Great Yarmouth Third River Crossing Application for Development Consent Order

Document 6.7: EIA Scoping Opinion

SCOPING OPINION:

Proposed Great Yarmouth Third River Crossing

DESIGNED BY	INITIALS	DATE	DRAWING No.
	DE	May 18	GYTRC-WSP-RLB-XX-DR-D-0001
DRAWN BY	EL	May 18	PROJECT TITLE
CHECKED BY	YS	May 18	GREAT YARMOUTH THIRD RIVER CROSSING
APPROVED BY	MD	May 18	SCALE
			FILE No.
			NTS
			0001

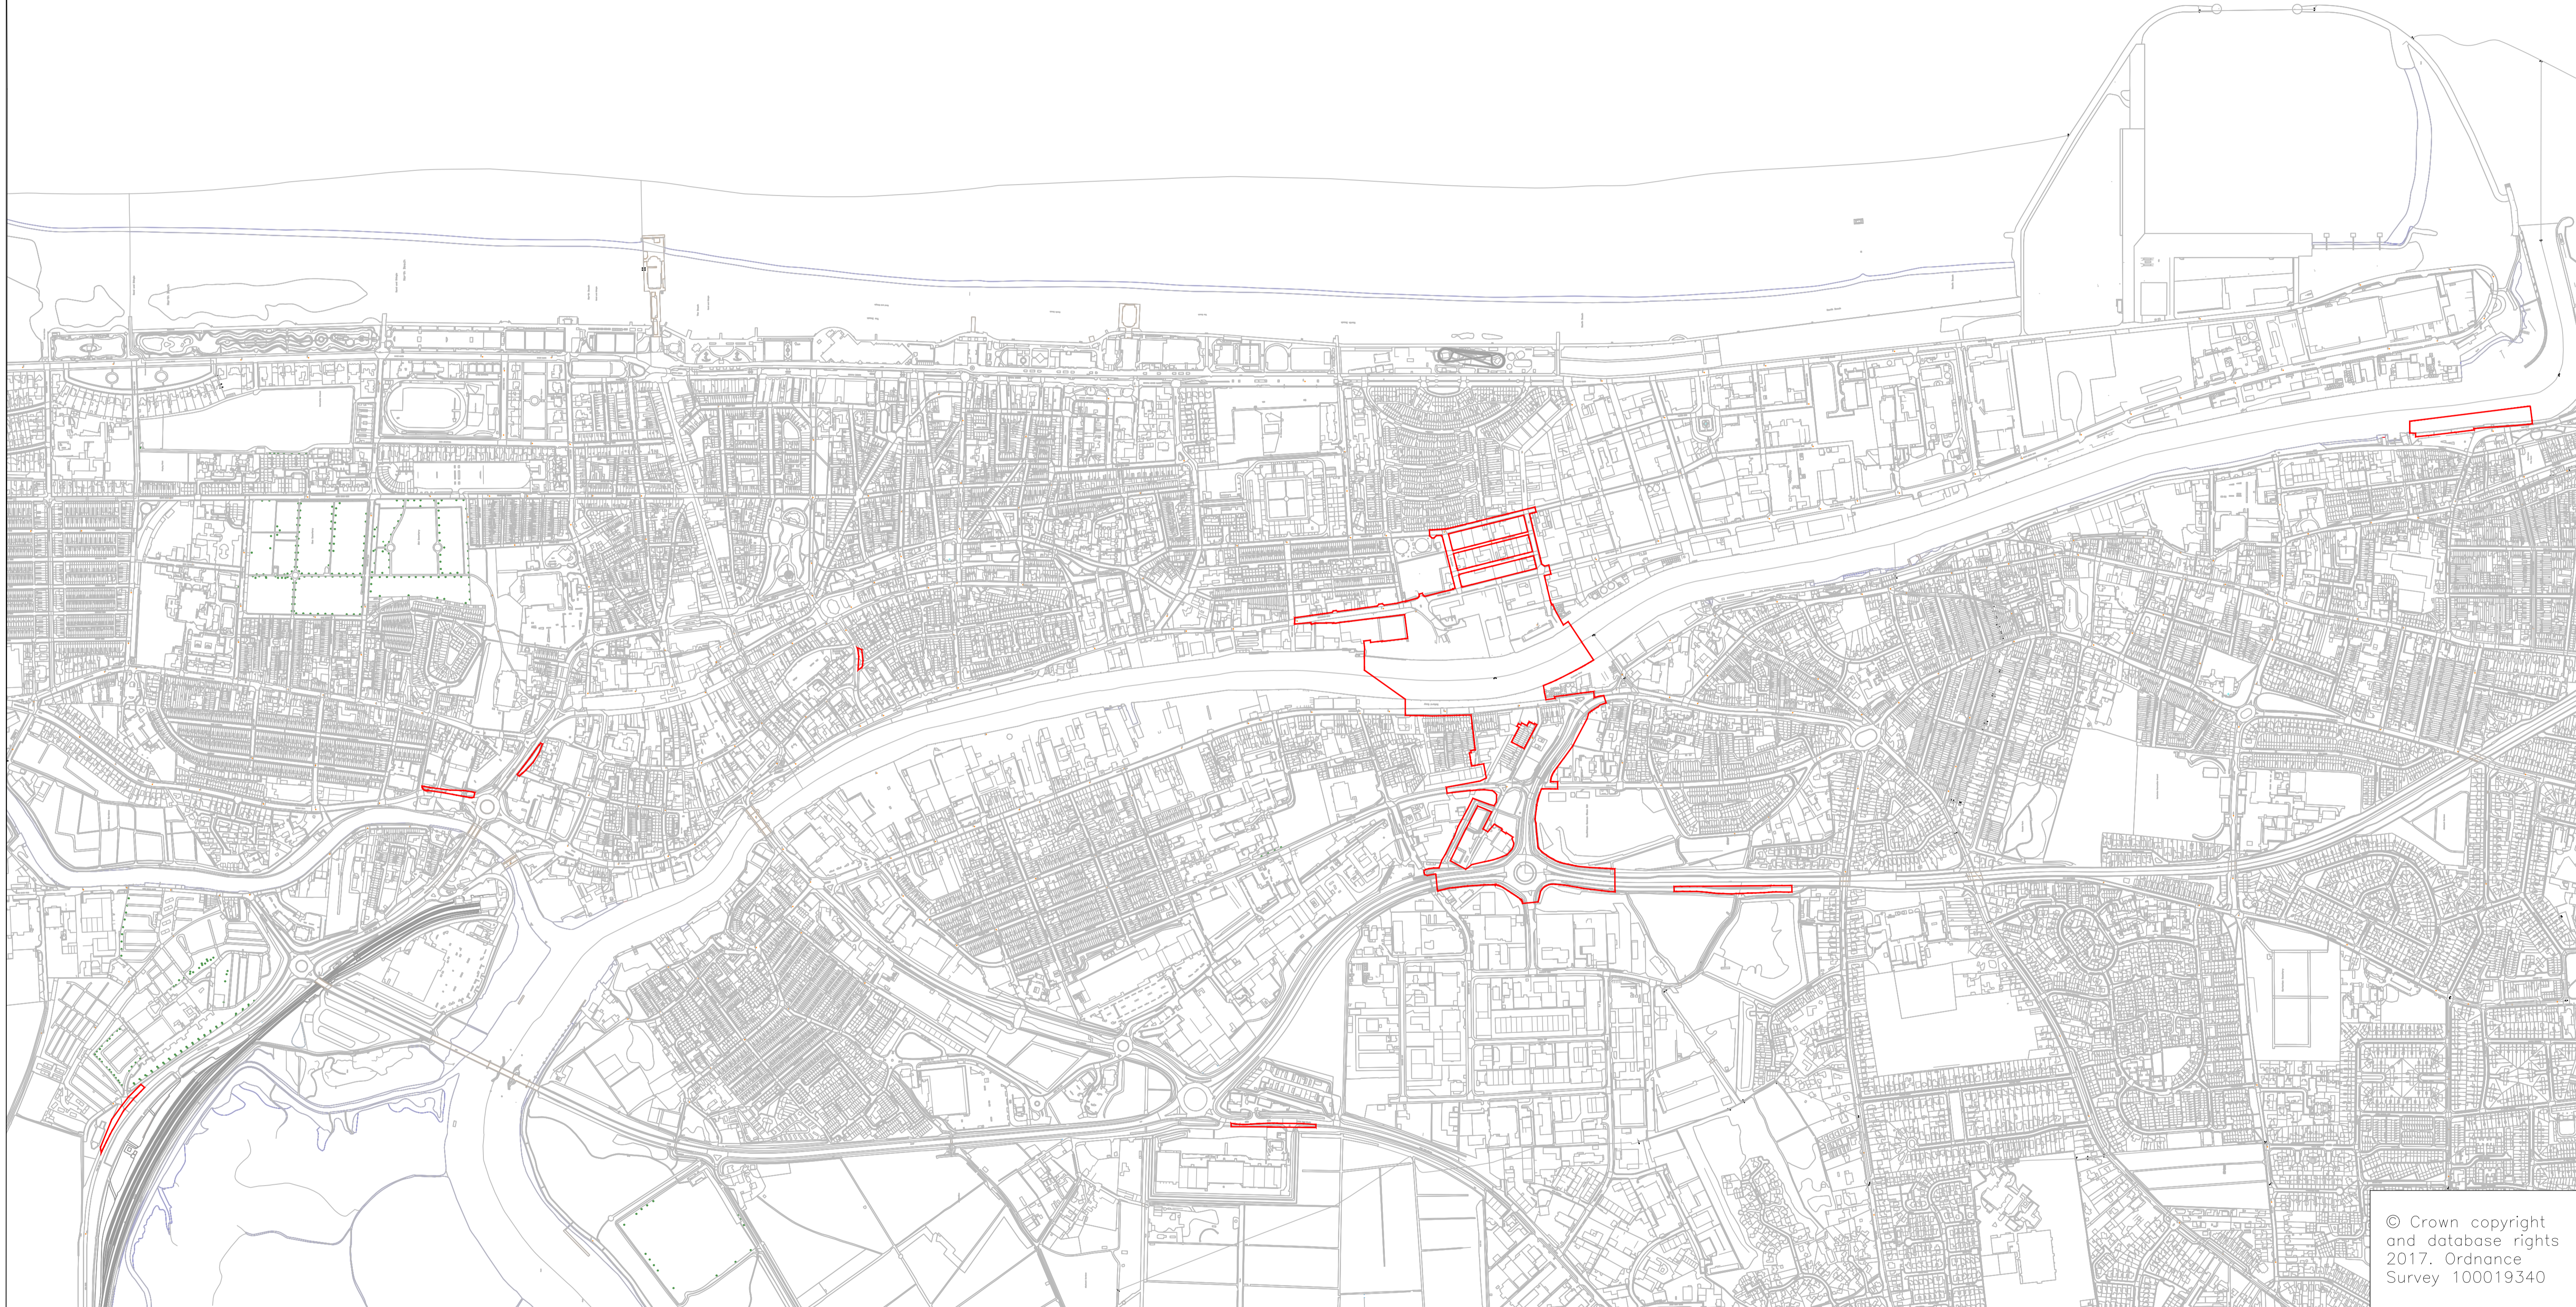
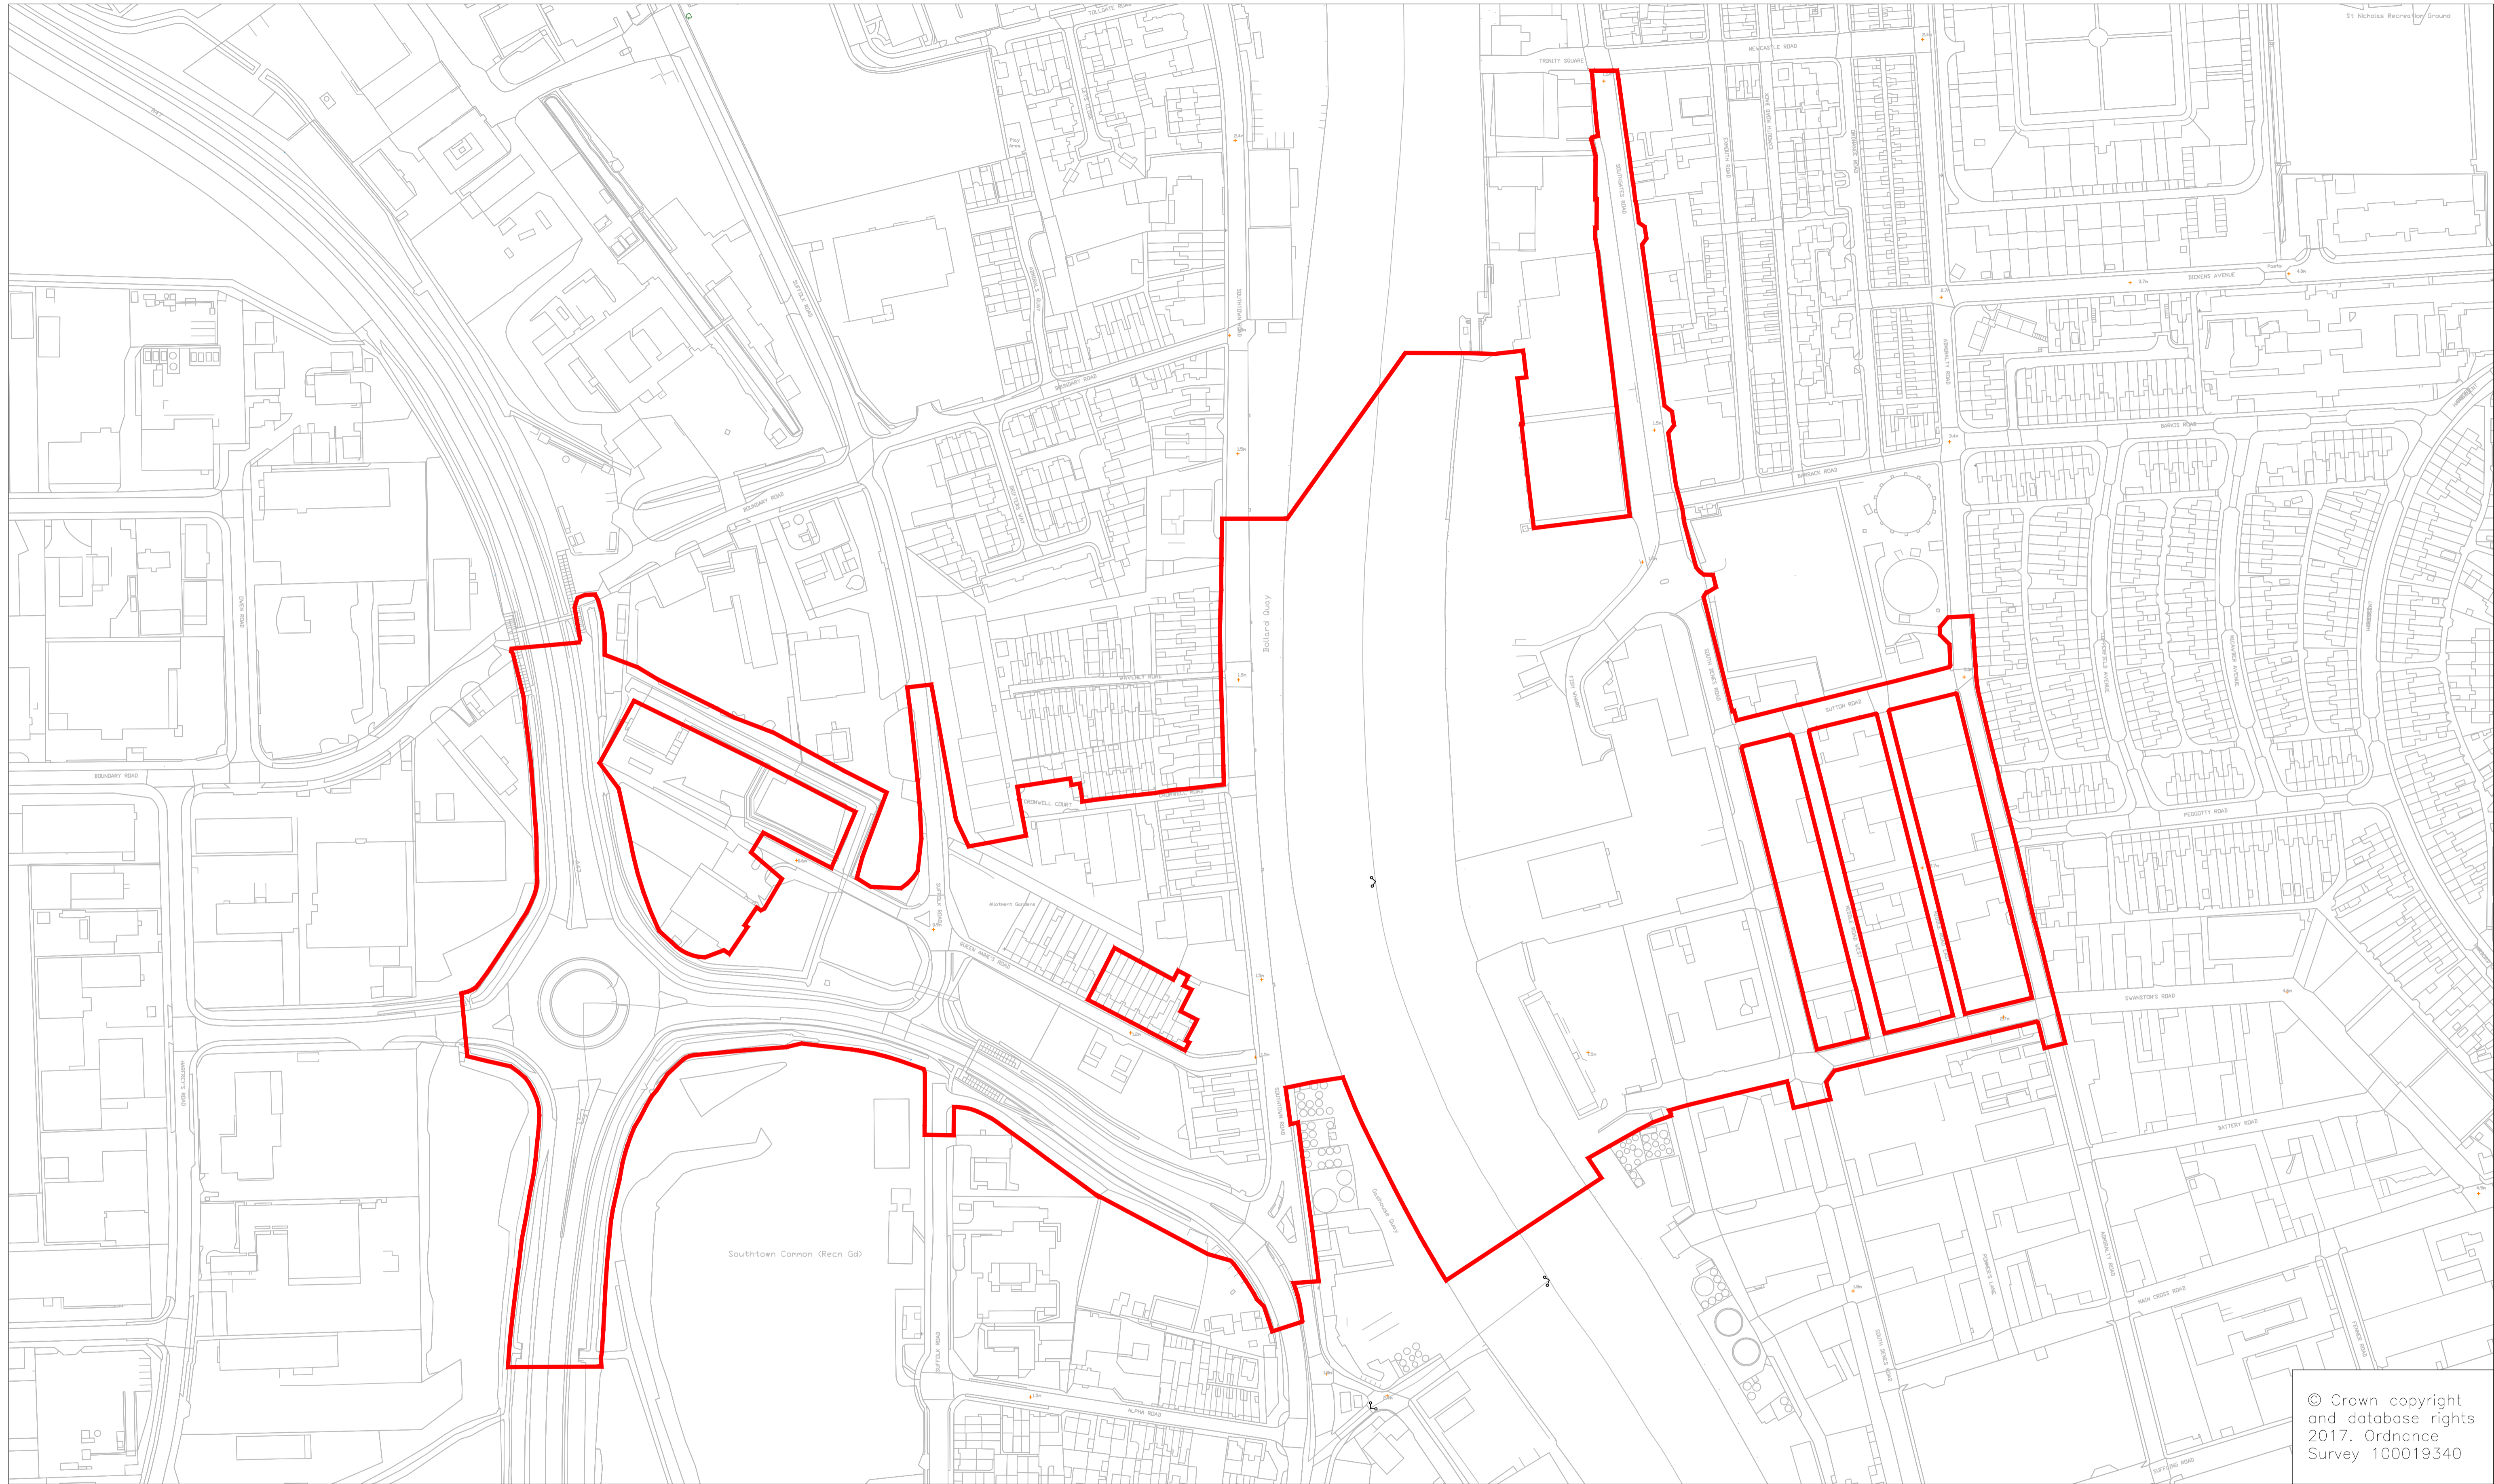
- 2.3.1 A description of the Proposed Development has been provided in Section 2 of the Scoping Report, supported by drawings and figures. The Inspectorate notes that the site boundary shown on Figures 2 to 5 in Appendix B is slightly different to the Scoping Report Boundary presented on drawing 62240375-GYTRC-Scoping Report Boundary-20180219. The Applicant should ensure the DCO application boundary for the Proposed Development is consistent on all drawings and figures that present this information in the ES, and ensure that the impact assessments have considered the full extent of the final DCO application.
